**Our Ref: WA/18/12/
Your Ref:**

Application for Planning Permission for Works or Extension to a Dwelling

Development Ground floor alterations, conservatory to rear elevation and a loft conversion

Location 10 Parsons Walk Walberton

EXISTING SIDE ELEVATION - EAST FACING

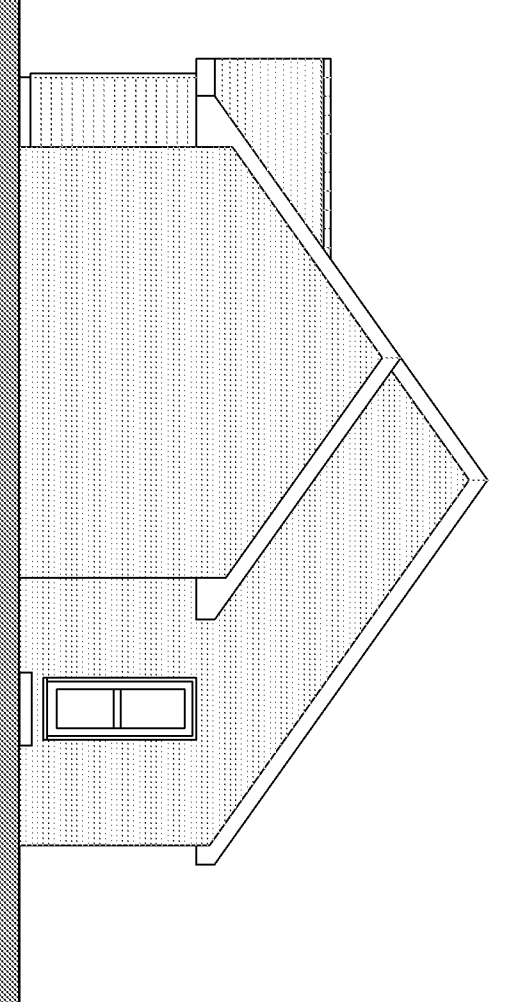
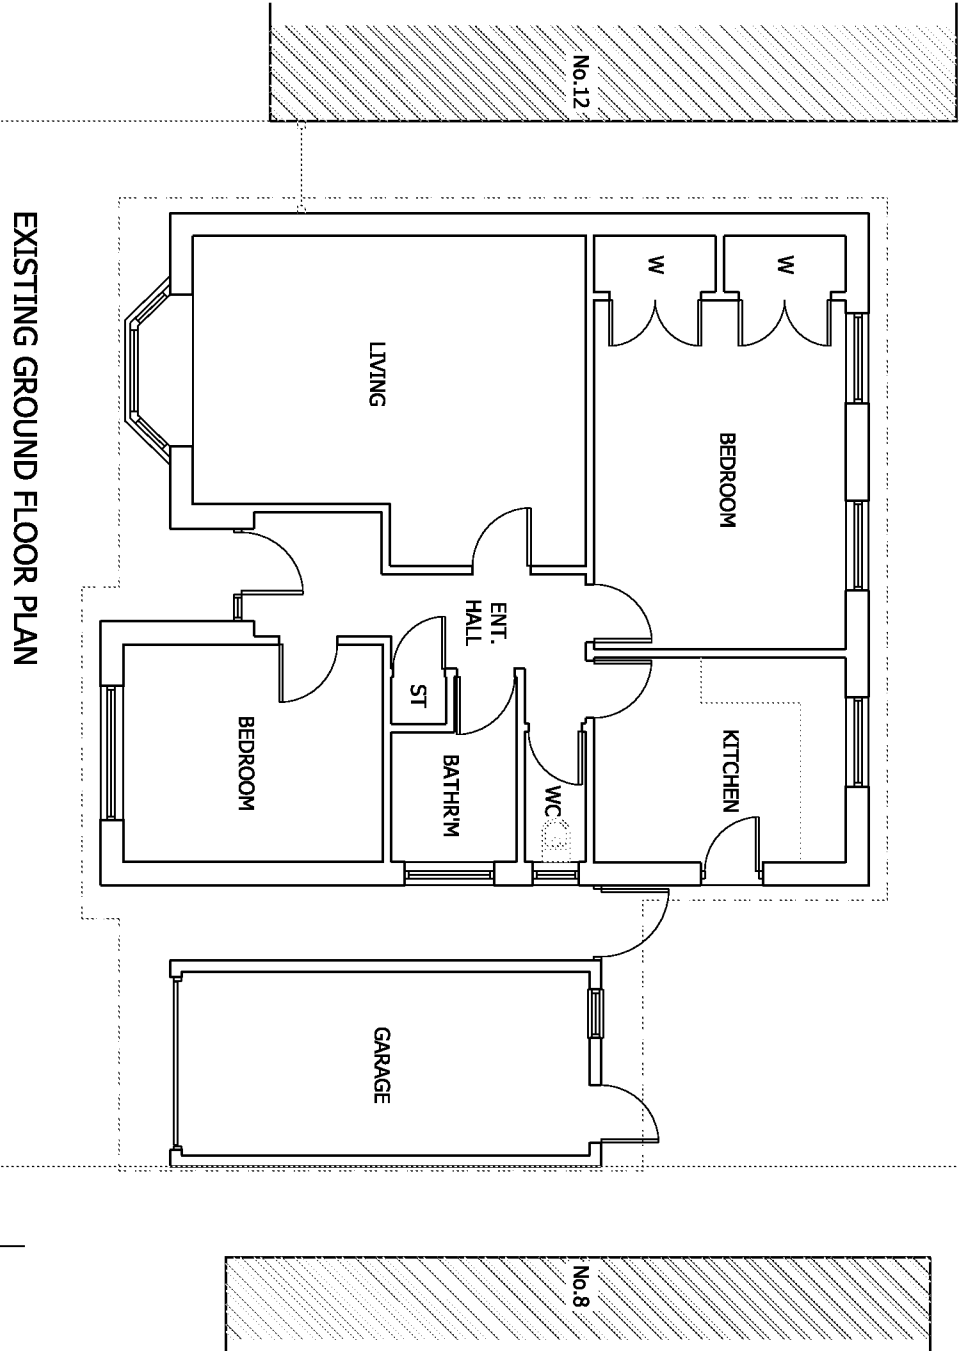
The existing East elevation does not accord with the existing East floor plan. Please amend accordingly.
